Engineers Comments Regarding Surface Water Drainage

APPLICATION NO: BN/66/19/PL

Site Address: Land off Canal Mews Barnham PO22 0AB

Description of Works: Erection of 3 No dwellings.

APPENDIX 5 – Sewage Treatment Plant Details

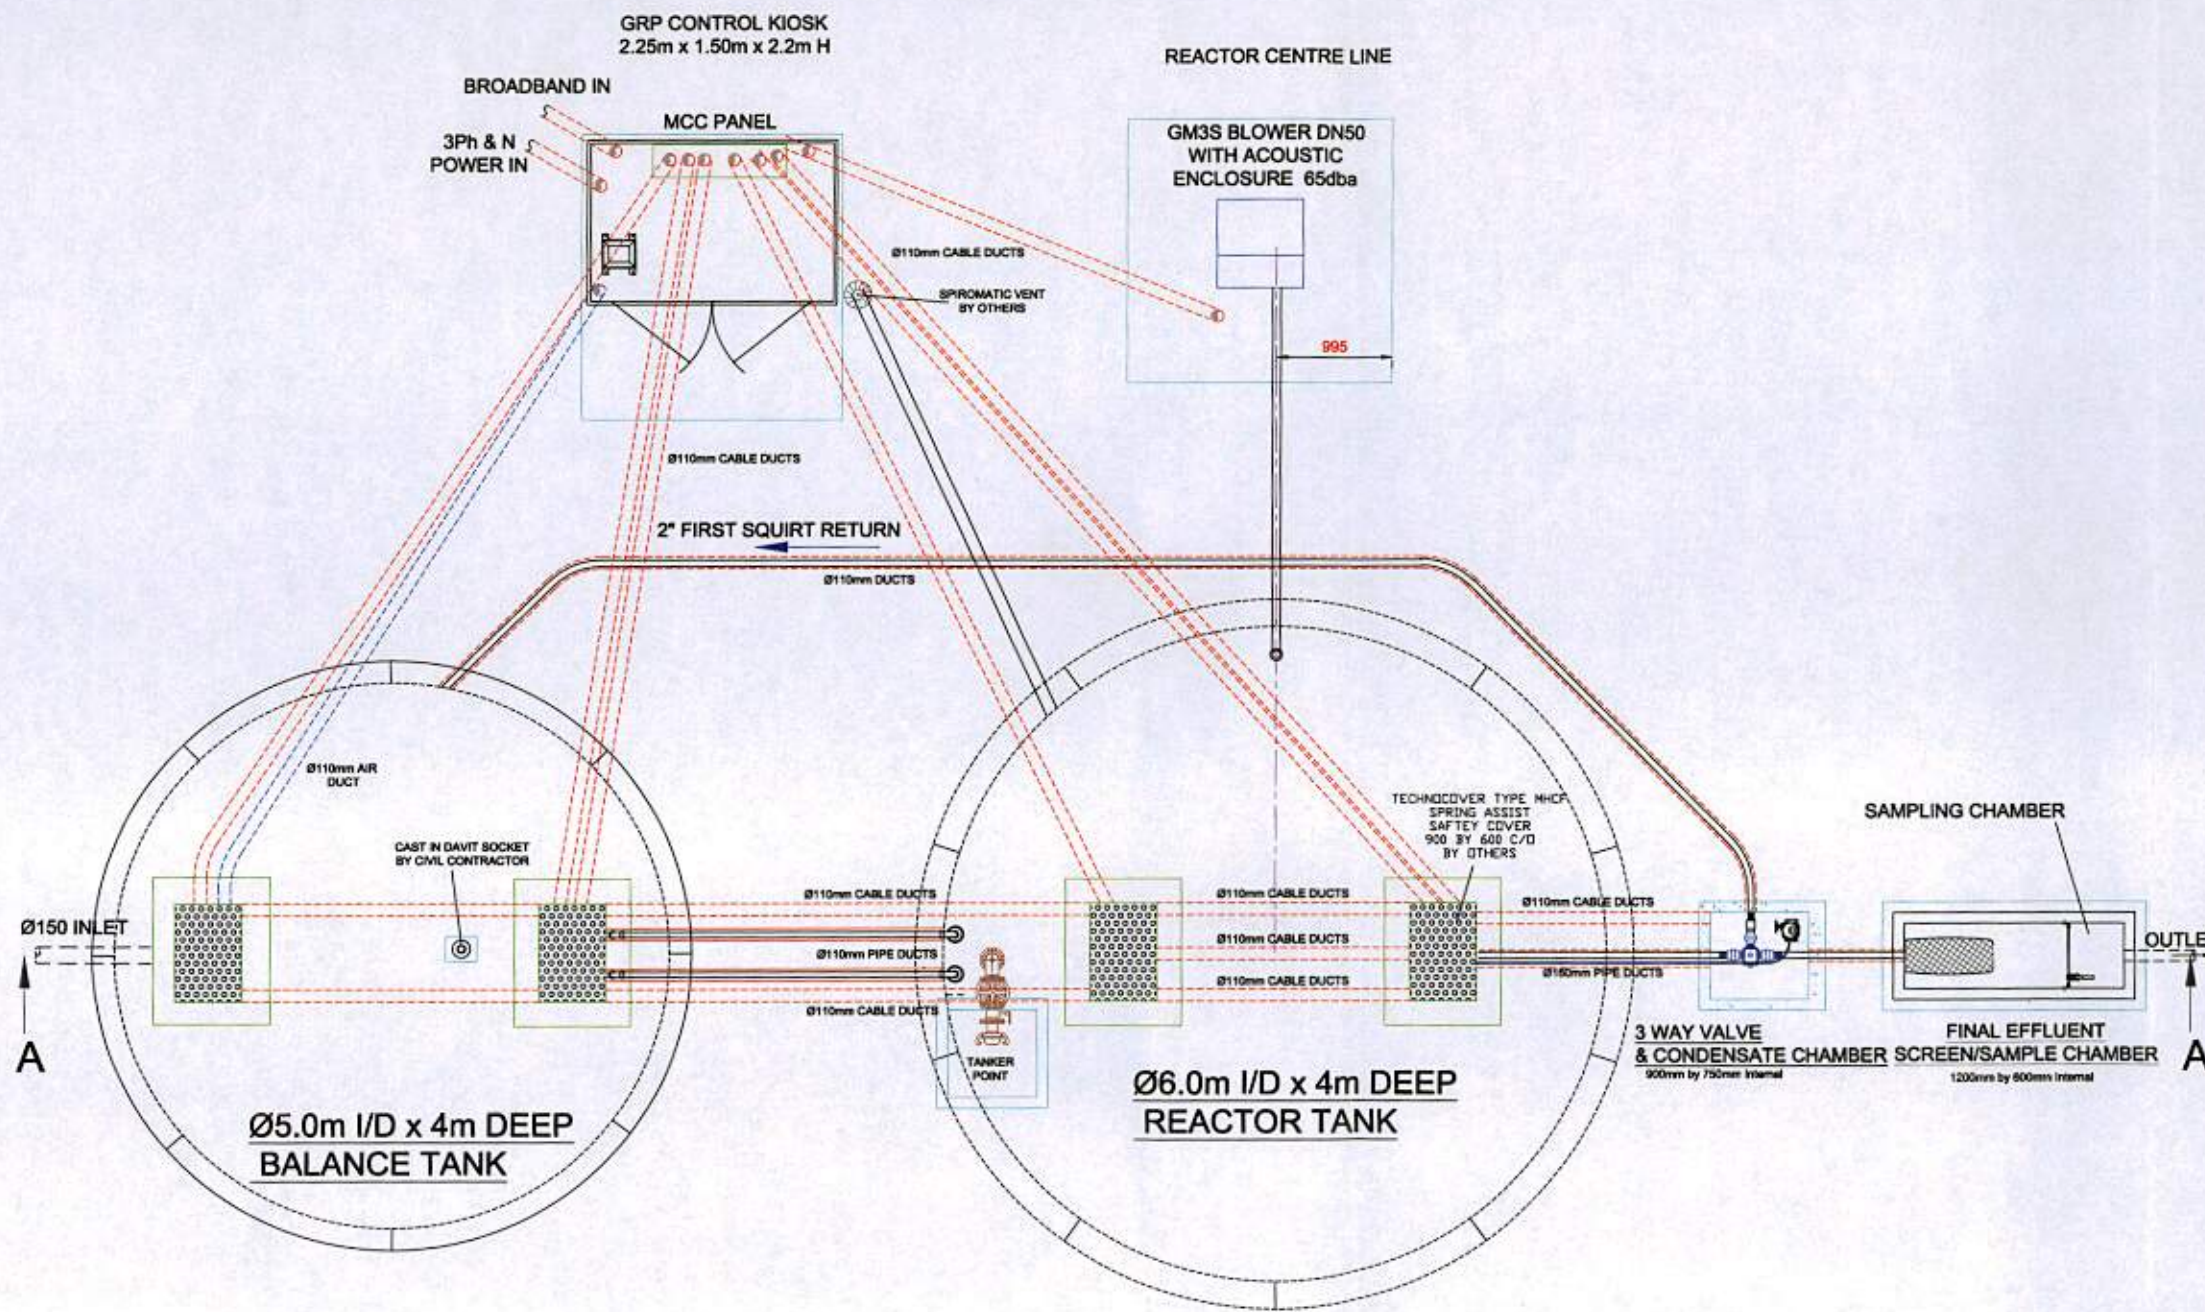
The development site 'Good Acres' has been approved under reference BN/13/14/ and under BN/25/14/DOC the condition 7 (Foul Water System) has been discharged: 'A gravity sewer will collect foul water and convey it to the proposed treatment plant south of the emergency access off Barn Rise.' accompanied by the drawings showing the plant on the site.

Full details of the foul water drainage system constructed as an alternative to the sewage treatment plant that was originally proposed.

It appears that the documents submitted in support of a discharge of conditions application (reference BN/25/14/DOC) for the wider site indicate that a foul water treatment plant is located in the area of the proposed development. Please can the applicant confirm if this is the case or not. Until such time as this confirmation is provided we object to the application.

The applicant has been in discussion with Croudace Homes and obtained the two attached letters from Southern Water confirming that the foul drainage system has been connected directly to the mains drainage, 'underground storage tanks' were not installed.

What we think has happened in relation to Laura Gibbons comments, and one of the residents is that originally our application site was earmarked for a sewerage treatment plant but this was never constructed as it was found to be feasible to connect all the houses to the existing foul water sewerage system directly. Perhaps they are citing out of date drainage plans?
